**Application for a non-material amendment following a grant of planning permission,
Town and Country Planning Act 1990**

**Non material amendment to previous permission 2016/91501 for erection of first
floor side and rear extension, single storey rear extension and vehicular entrance
gates (within a Conservation Area)**

Braystone House, 32a, Wilshaw Road, Meltham, Holmfirth, HD9 4DZ

Application Number: 2016/93572

title plans & sections as proposed
 number 16026D-05-P01
 scale 1:50 or as shown
 size A1

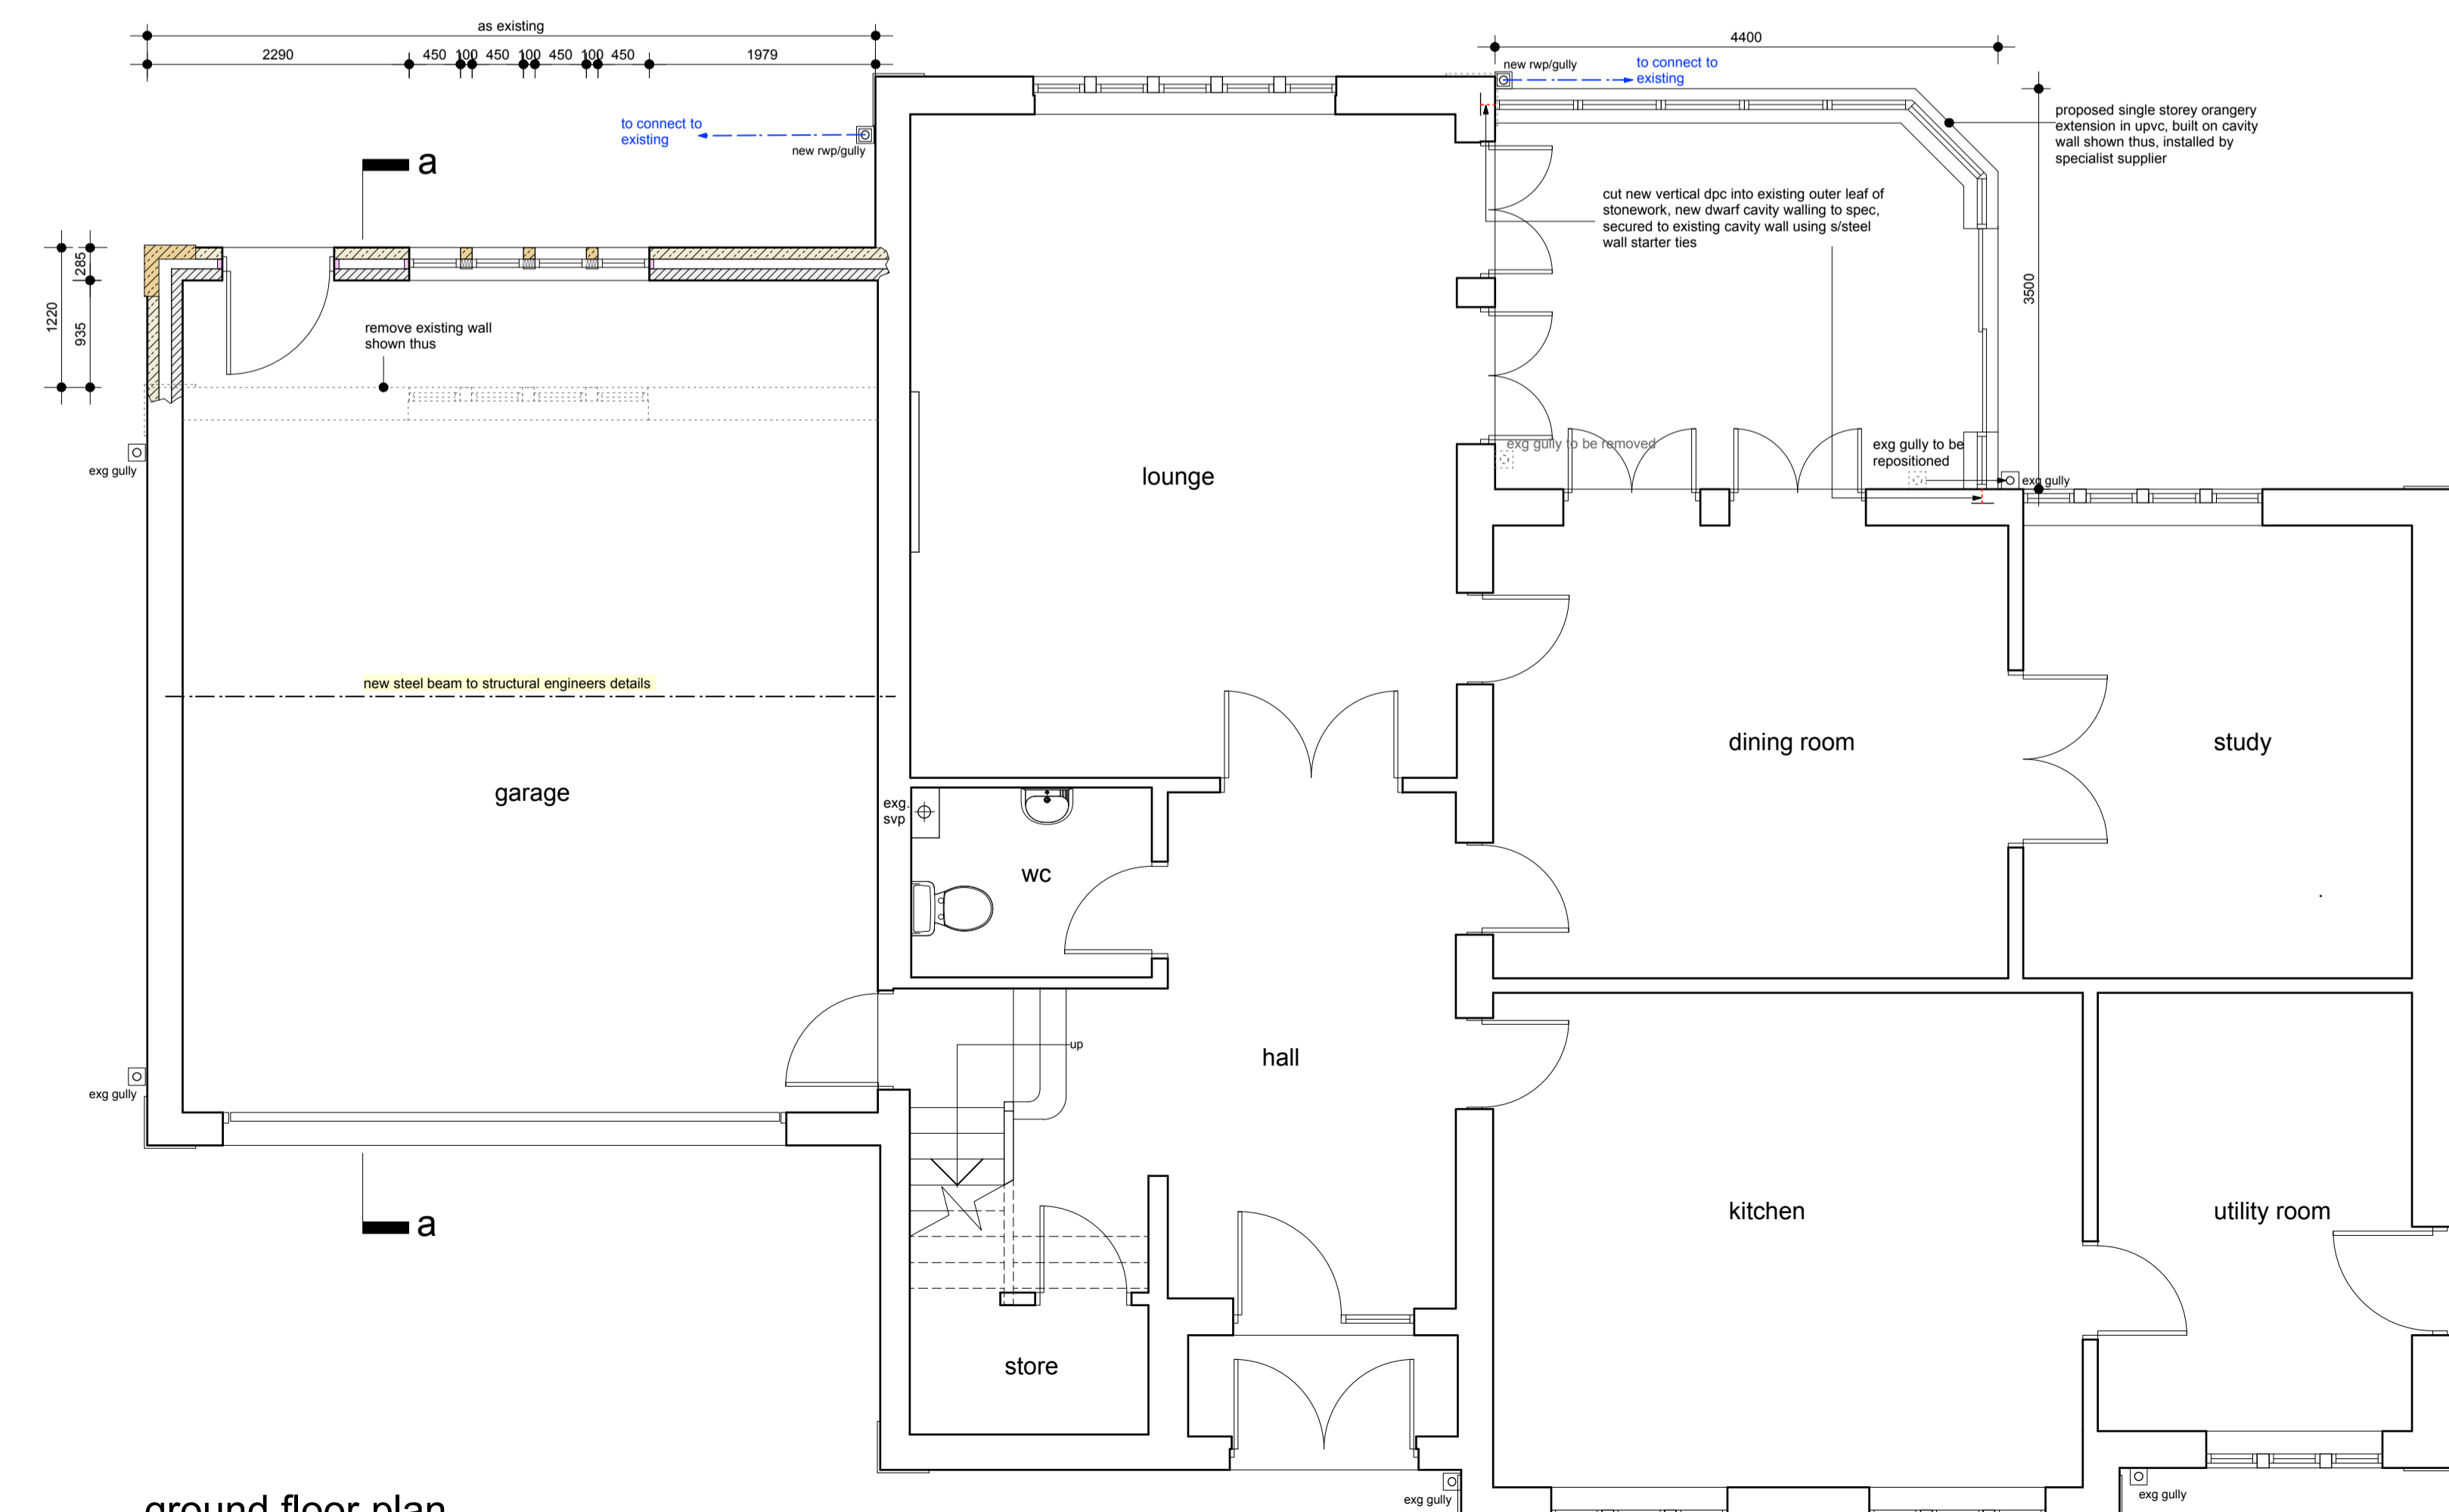
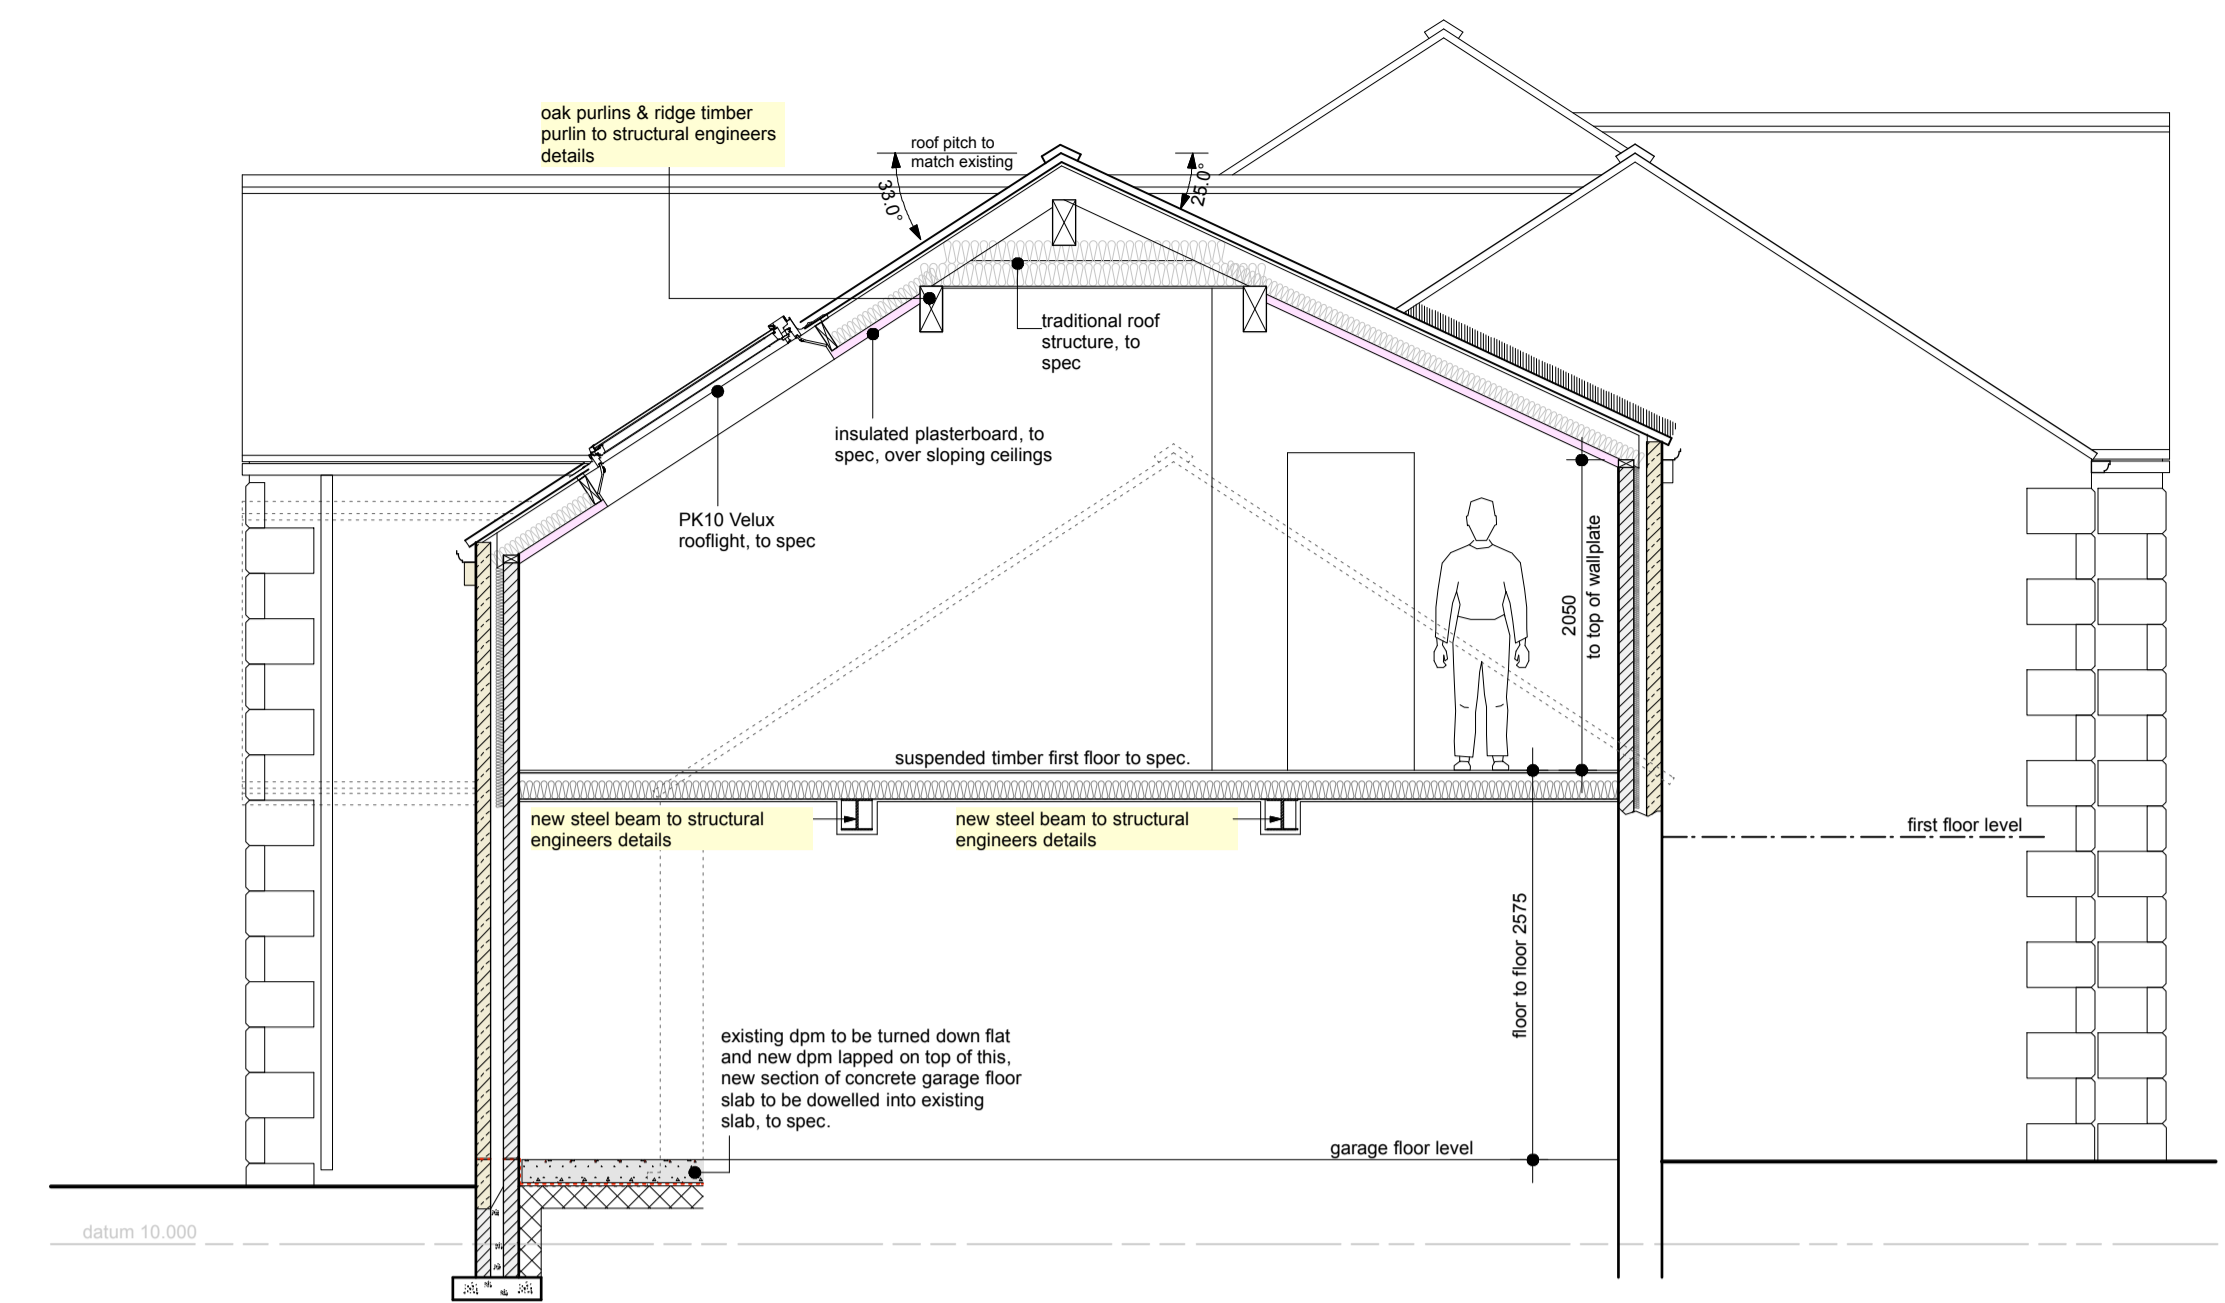
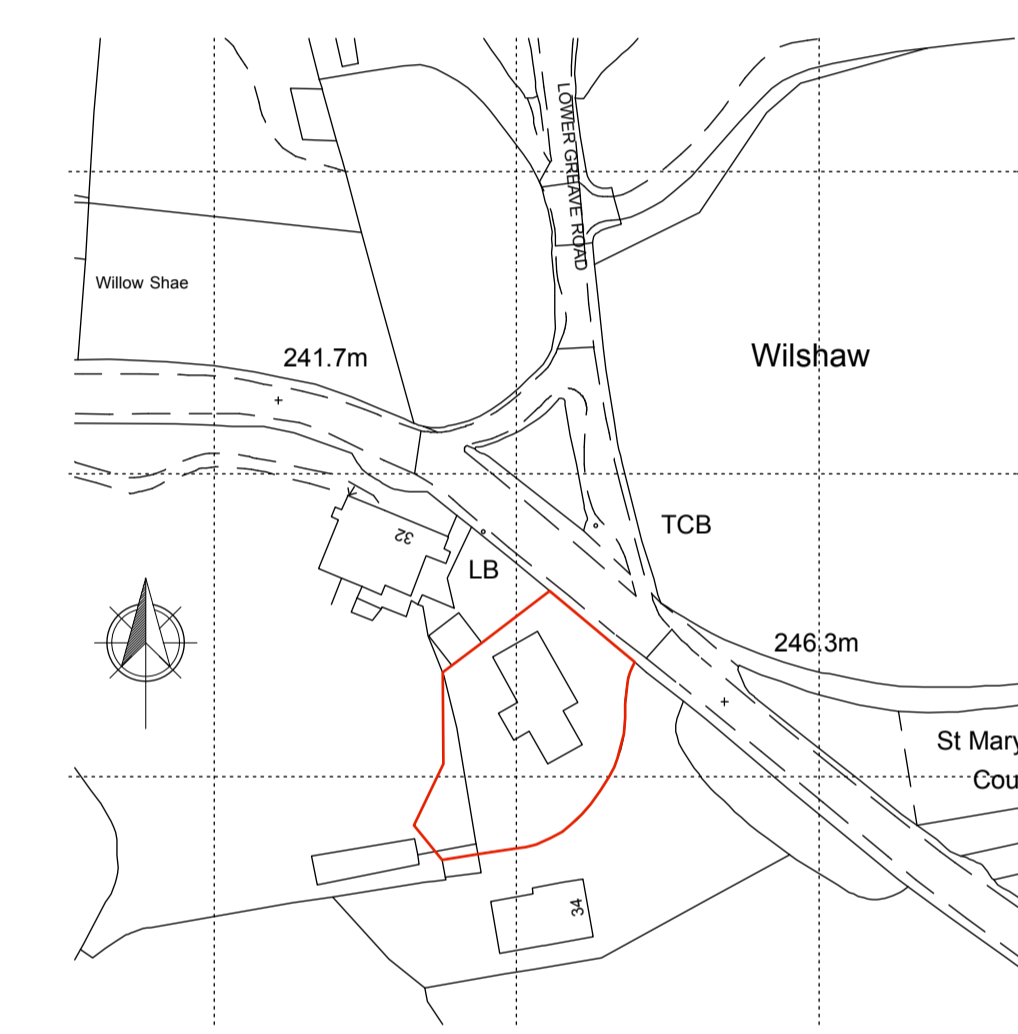
Thank you for your application dated 21-Oct-2016 for a non-material amendment to the above scheme. The amendment sought is to increase the height to ridge and eaves height of the side extension as indicated on drawing no.16026D-05-P01 titled "plans & sections as proposed" and drawing no. 16026D-06-P01 titled "elevations & specification as proposed" received by the Local Planning Authority on 25 October 2016.

I confirm that the alterations are acceptable and may be considered as a non-material amendment to the approved drawings. It should be noted that this letter relates only to the non-material amendment sought and it is not a re-issue of the original planning permission. The two documents should be read together and as such, all conditions imposed on the original granting of planning permission apply to the proposal as now amended. A copy of this letter and the amended plans will be retained on the public record of approved documents.
